Subject: FW: A/70/22/CLE- Arundel Acre

From: Anita Gardner
Sent: 25 July 2022 09:53
To: Joney Ramirez [REDACTED]
Subject: A/70/22/CLE- Arundel Acre

ARUNDEL ACCE	
ARUNDEL RD	
ANNE MOUNTAIN SUSSEX	
SCALE 1:500 METRES

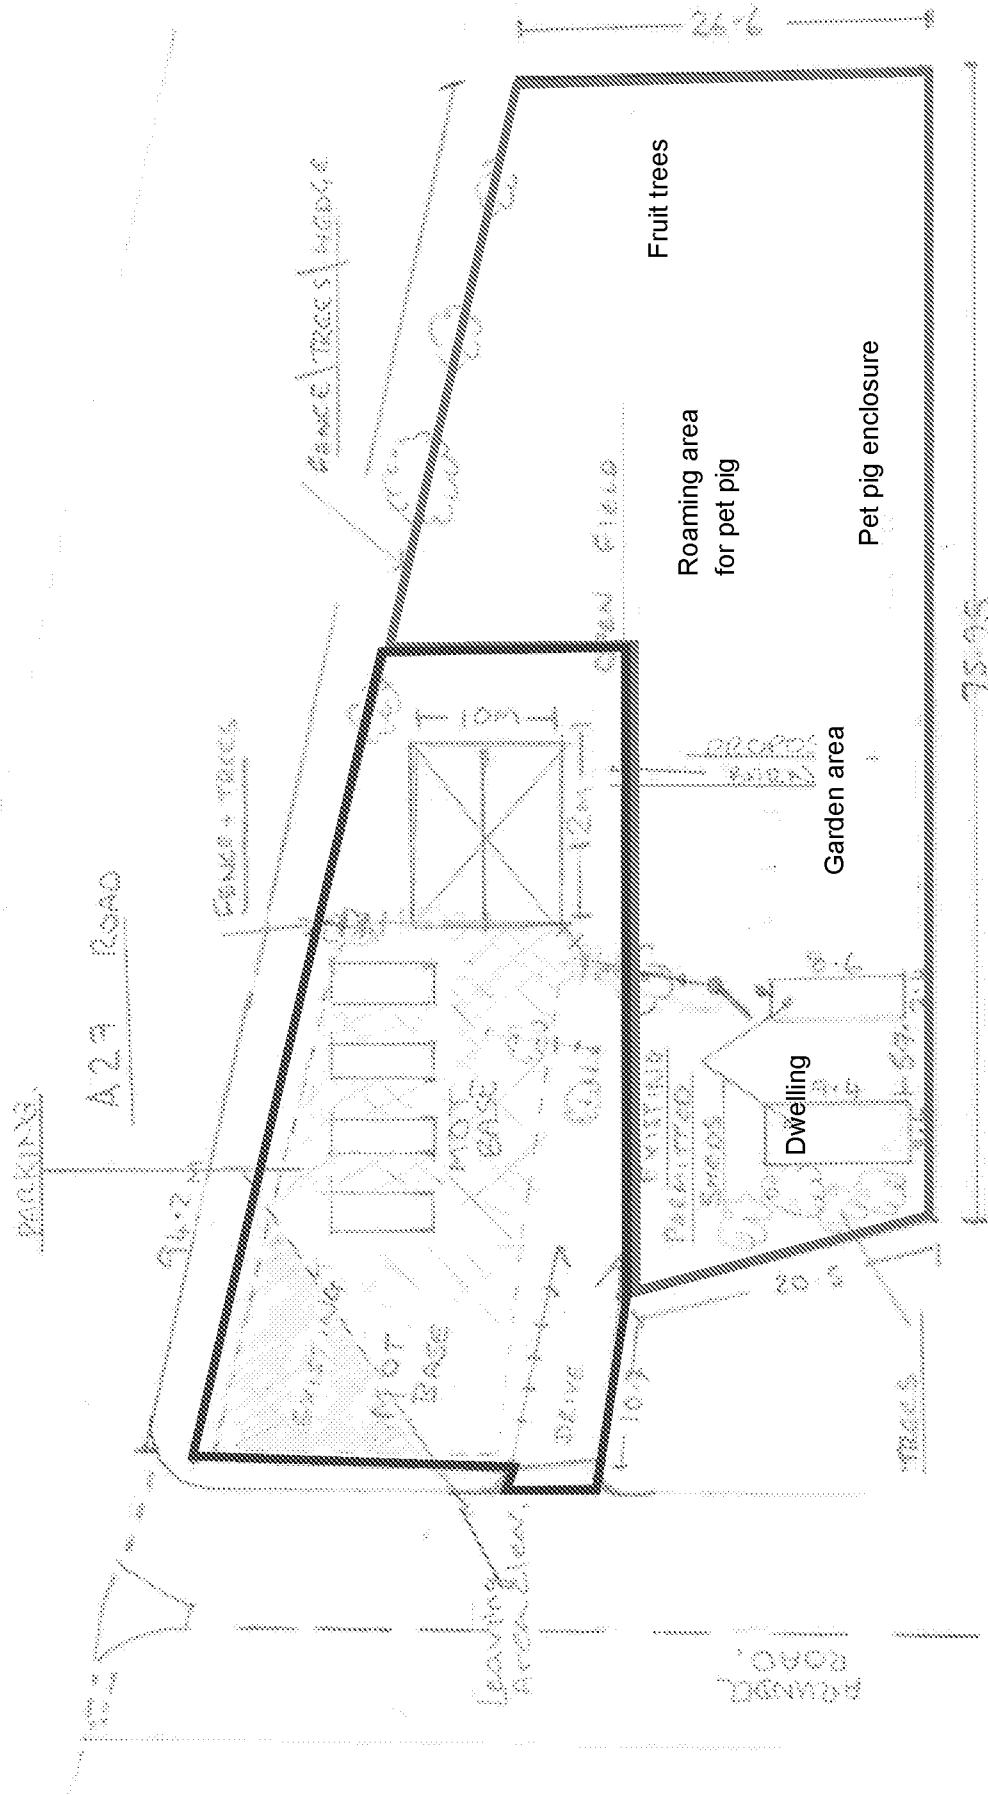
I am currently going through the evidence submitted with your application and note that there is no mention of the area of fruit trees being used as part of the dwelling within the statements or photographs and I am therefore querying whether the red edge should be reduced accordingly.

I also note that the red edge indicated does not correlate with our Arun Mapping system. The dwelling is shown parallel with the curtilage and the boundary is straight and I believe it is angled slightly. Can you please let me have a more accurate plan that correlates better with our mapping system since I want to ensure the Plan produced accurately reflects the area you have indicated. Could you provide a plan based on our system?
